Ref: SSD-70557215
Enquiries: Craig Wilkinson

**State Significant Development – SSD-70557215 – Hillview Hard Rock Quarry Project –
Council Second Submission**

With reference to the current State Significant Development, being SSD-70557215, which is currently on exhibition at the moment, MidCoast Council wishes to provide the following comments in relation to proposed extractive industry:

**Figure 19: Stage3a intersection upgrades**

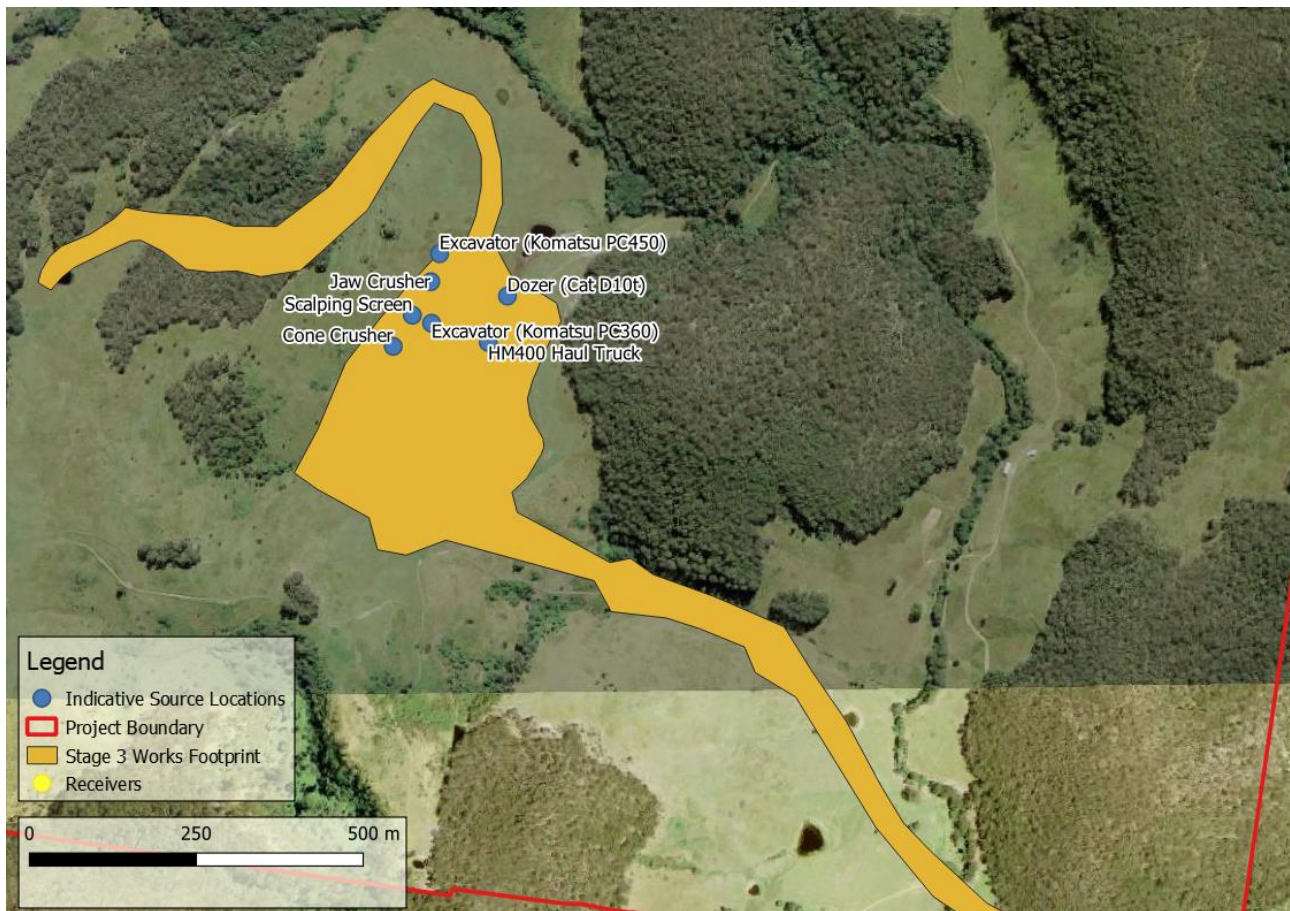
- A Road Safety Audit to assess the suitability of proposed BAR/AUL(s) intersection treatment at the intersection of The Bucketts Way / Maytoms Lane is required.

- The left turn movement of heavy vehicles from Maytoms Lane on to The Buckets Way results in encroachment of centreline. This is considered unsafe. The intersection design should cater for safe heavy vehicle turning movements.

- The intersection should be upgraded to a channelised standard similar to the intersection treatment applied to the Deep Creek Quarry with acceleration lane to the south. Design vehicle shall be a 30m B-double.
